# CITY OF ALBUQUERQUE

PLANNING DEPARTMENT – Development Review Services

May 25, 2016

**RE: Main Event, Albuquerque Carpenters Training Center (File: G16-D149)**  
**4040 Pan American Freeway NE 87107**  
**Grading Plan and Drainage Plan, Engineer's Stamp Date 5-14-2015**  
**Engineer's Certification Dated 5-19-16 sheet C5 only**

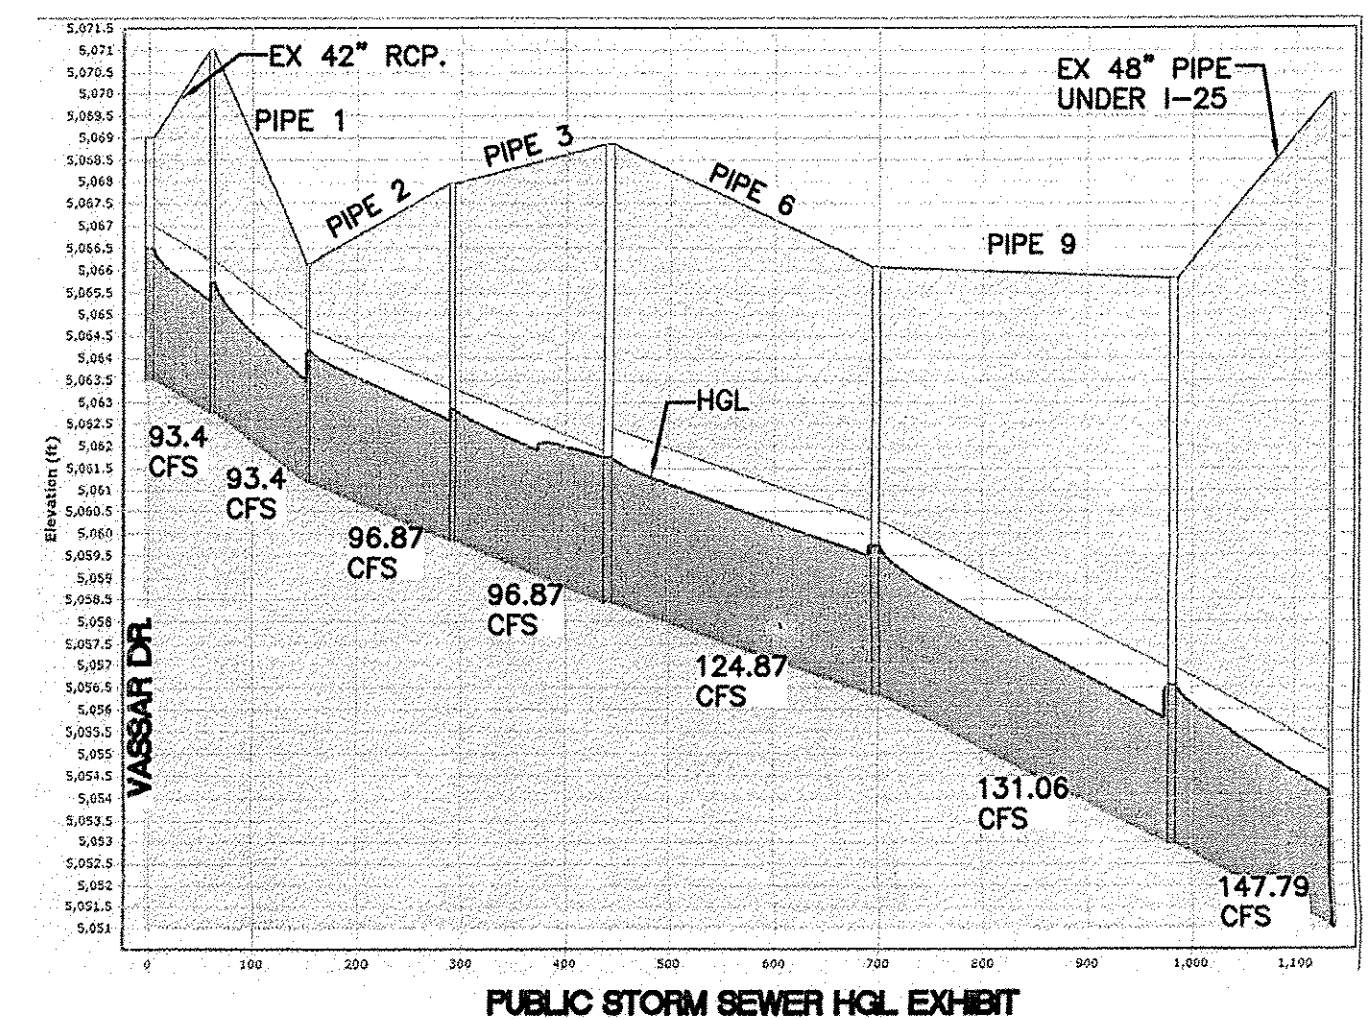
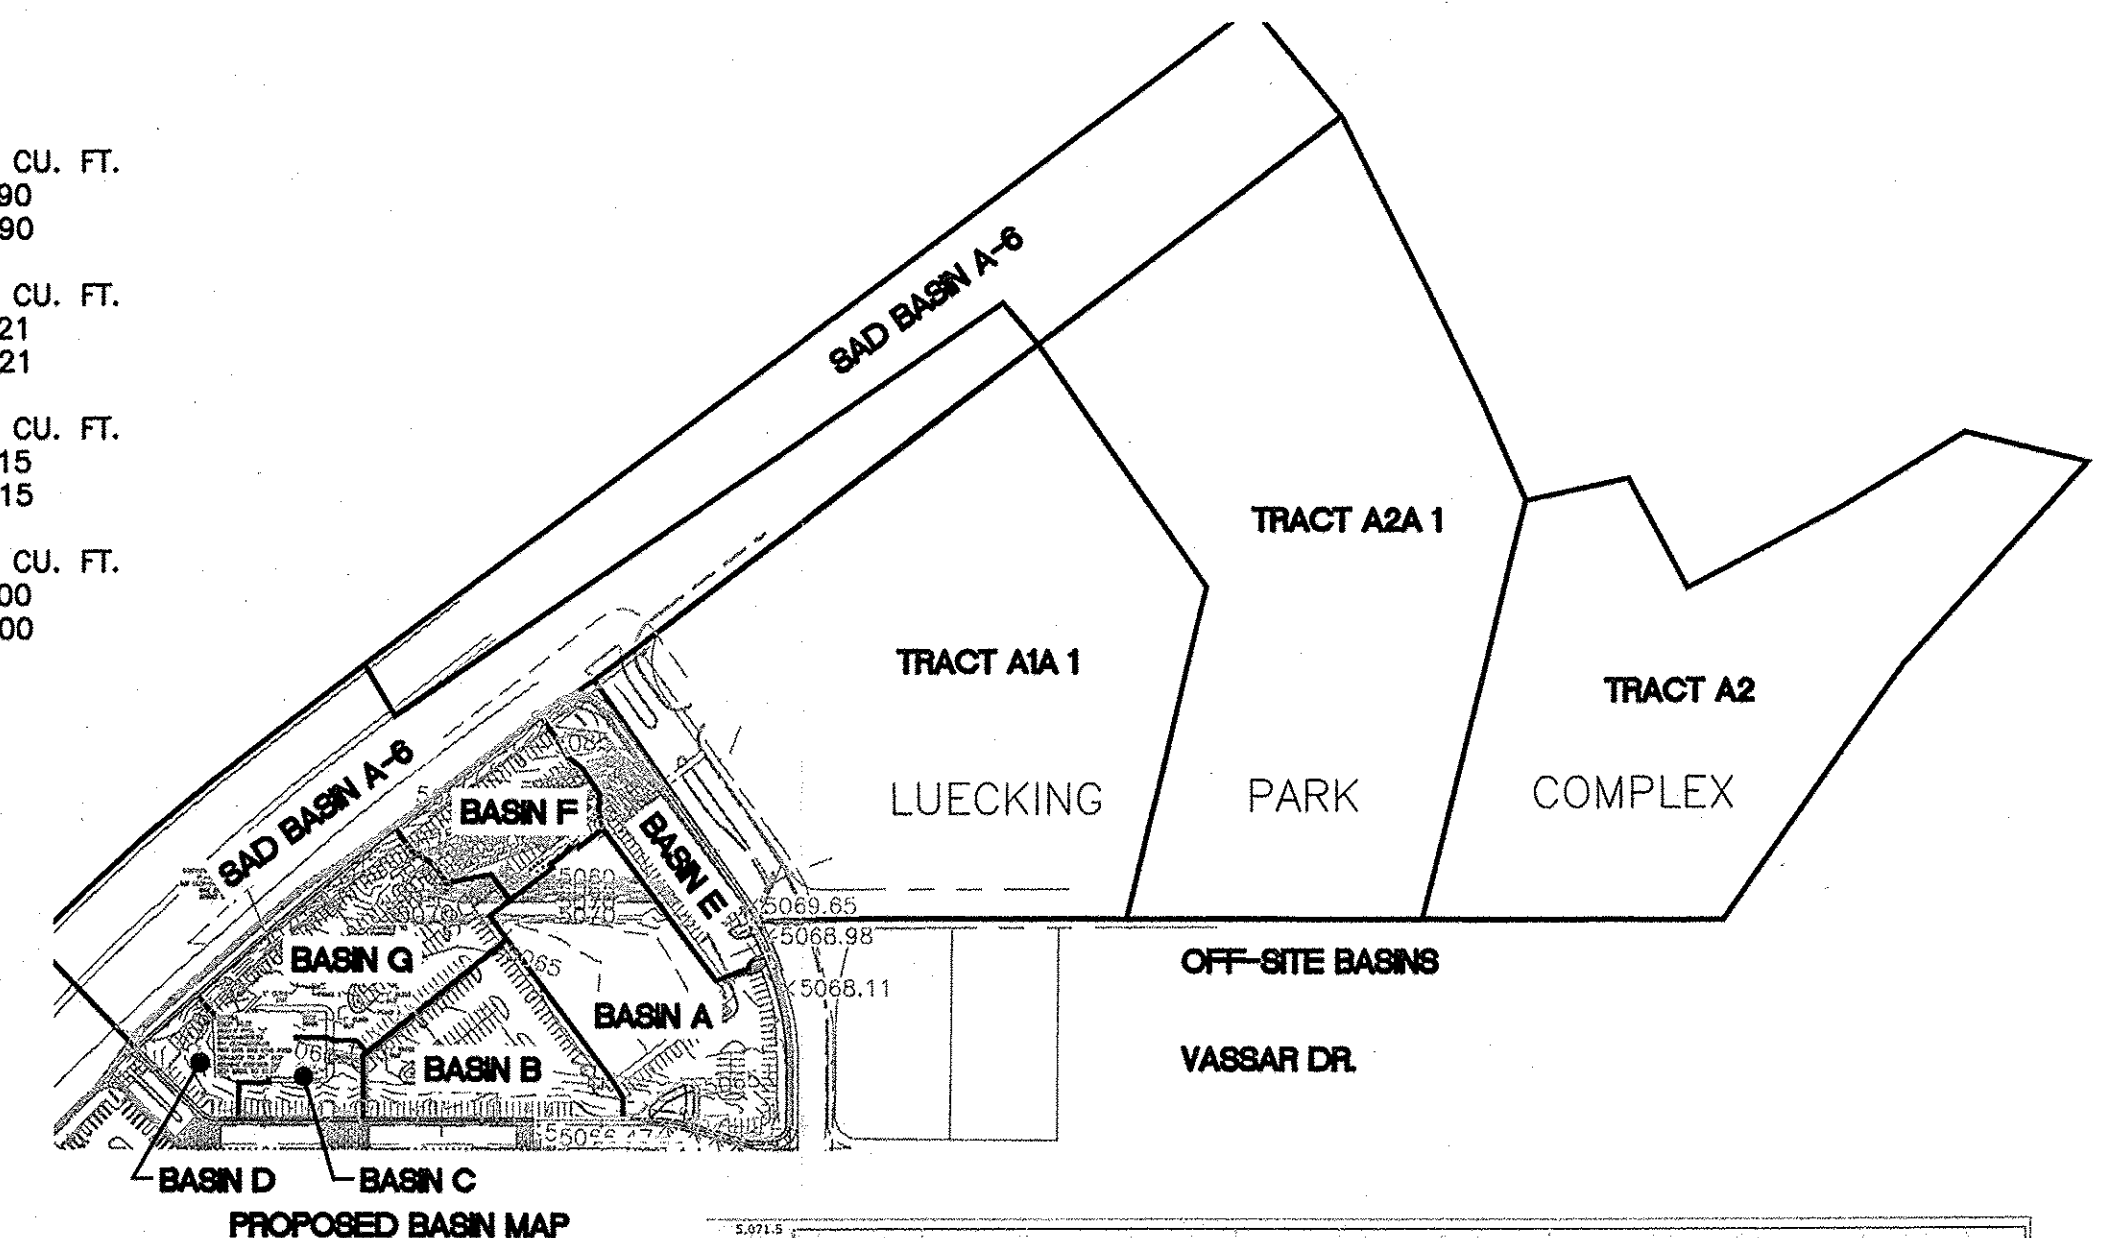
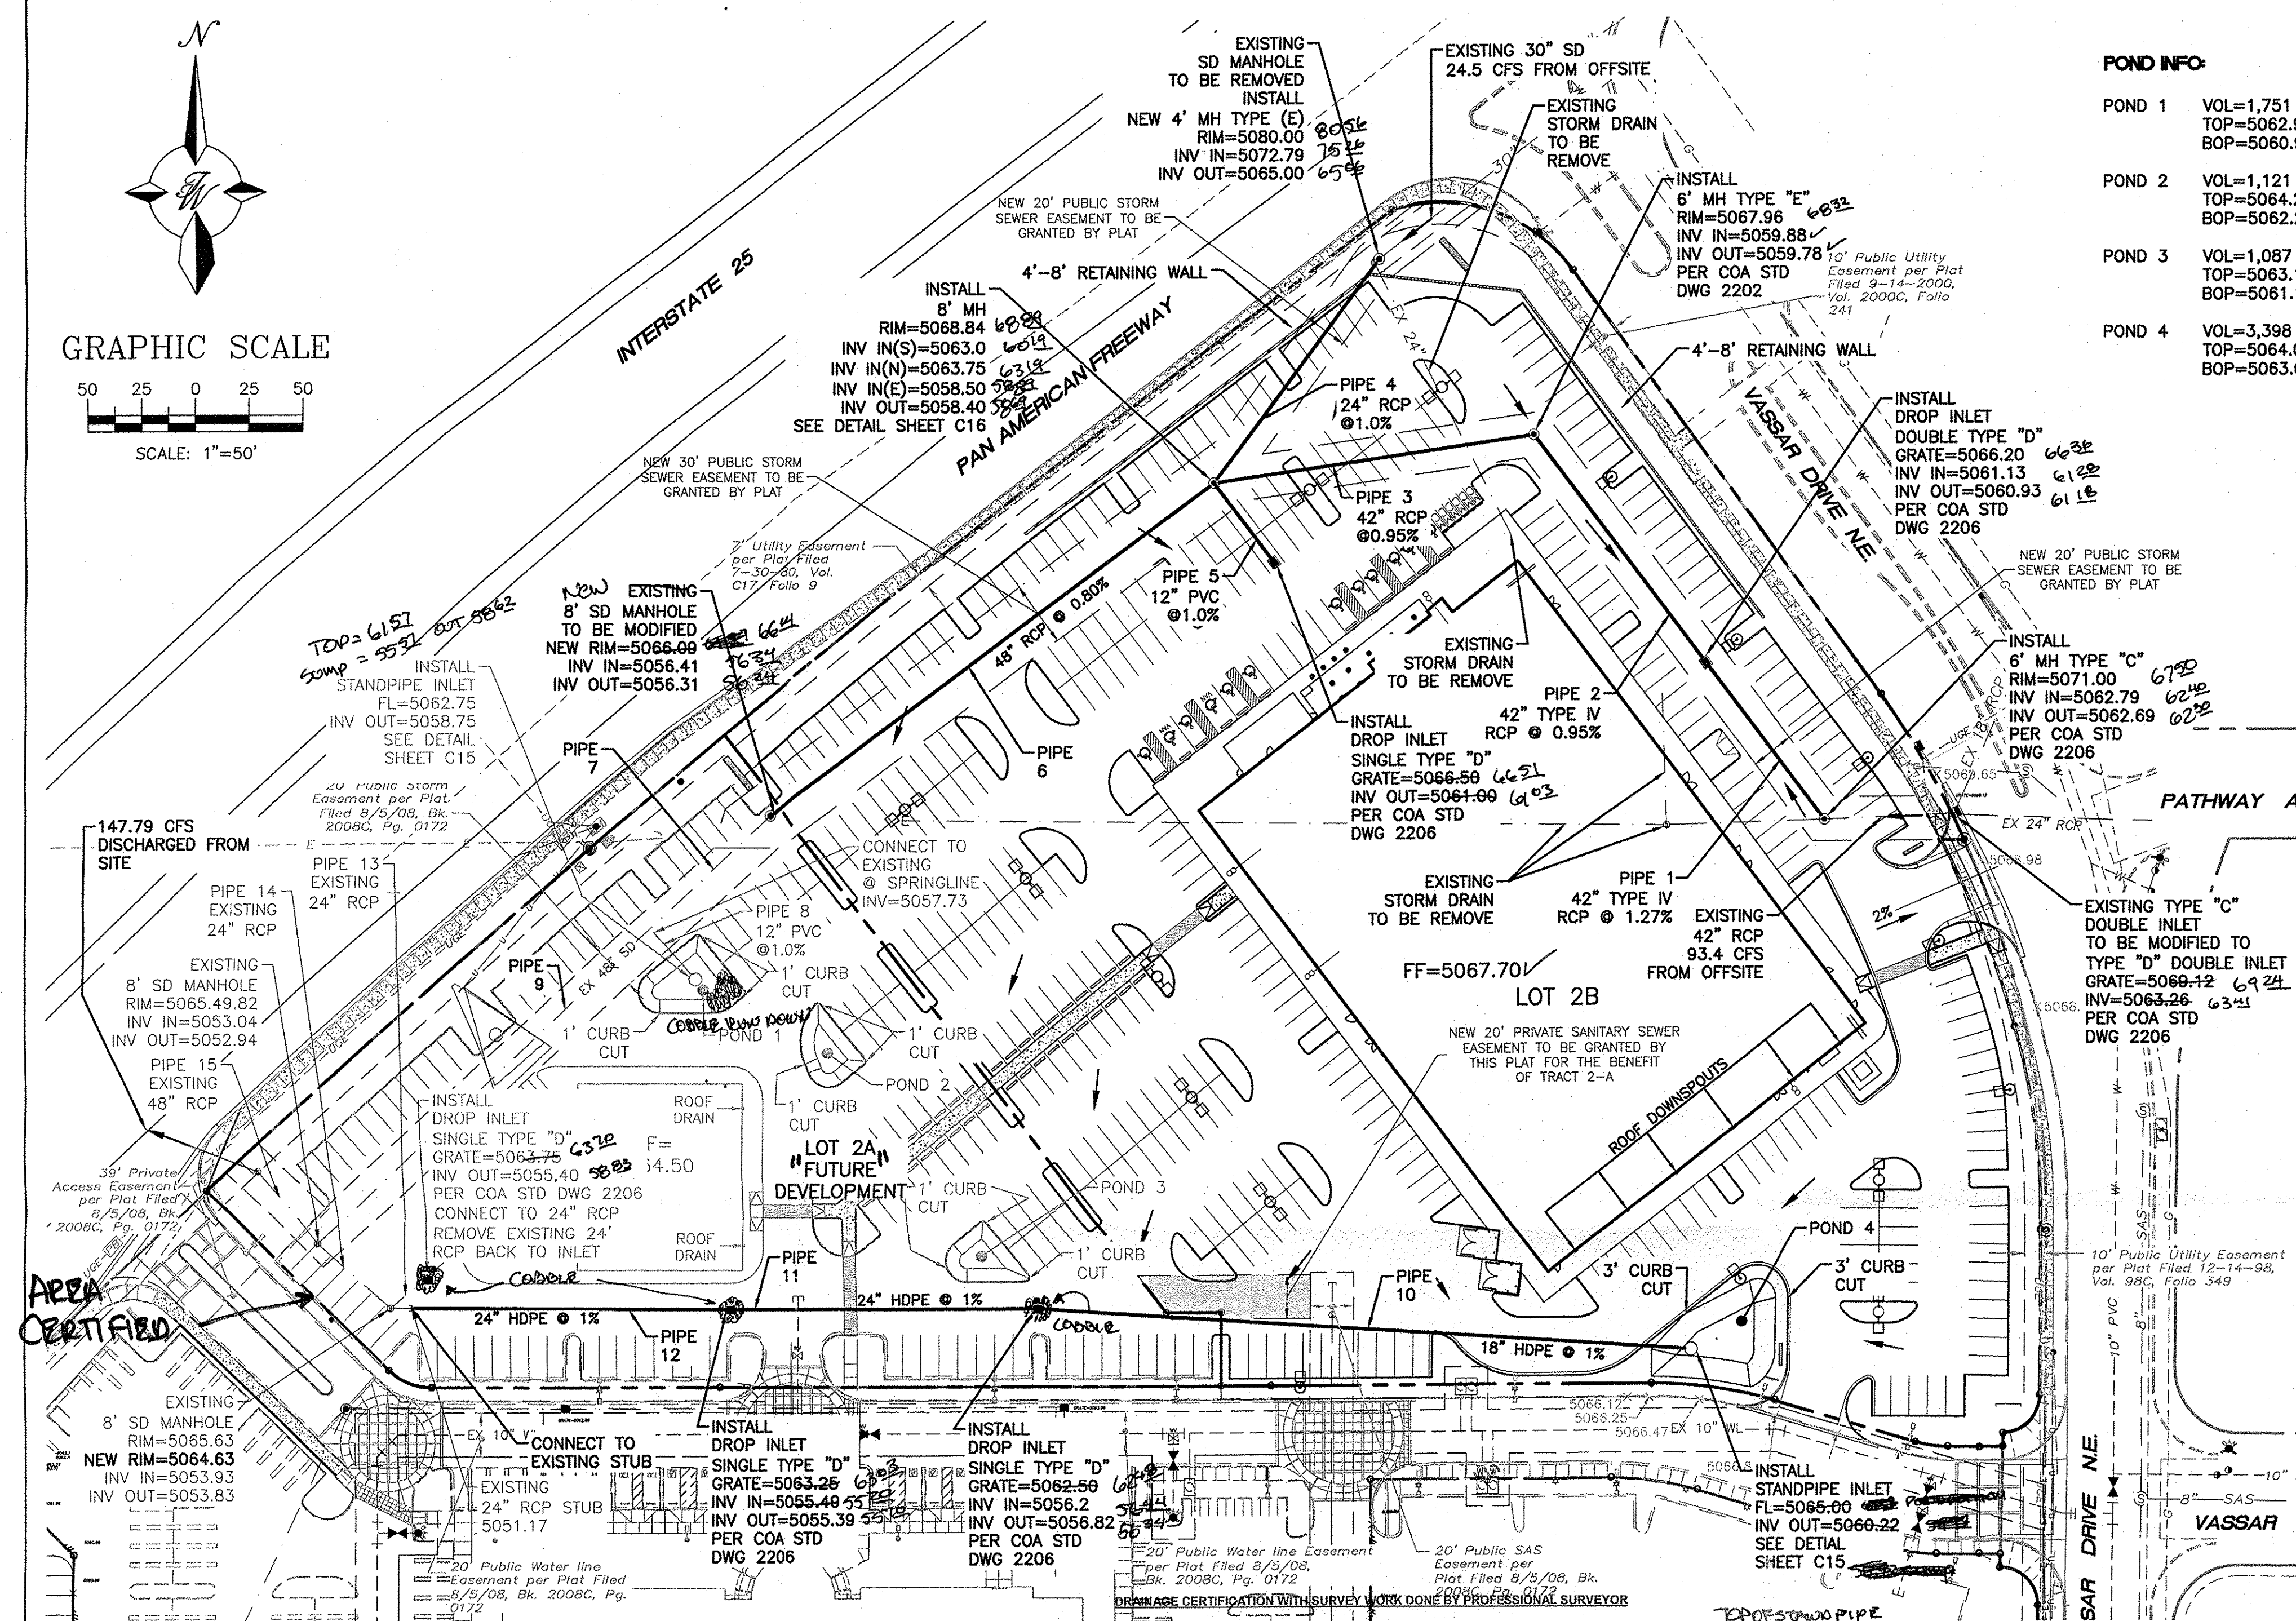
1. Drainage Plan, Sheet C6 must be Certified. All private Storm Drain improvements must be as-built and certified on this sheet.
2. Permanent ponds must be as-built and certified. Additionally, the interim sediment ponds that were to be built around the inlets on the undeveloped lot must also be certified. Curb-cuts need to be also shown on the as-built.
3. The Work-order for the Public Storm Drain has punch list items. Either the work-order must be accepted, or the punch list items completed:
  - Grout I-beam at modified double "D" inlet on Vassar Dr
  - Clip corner of concrete SD collar and remove excess concrete from SDMH at NW corner of site.
  - Grout MH barrel joints at NW corner of site.
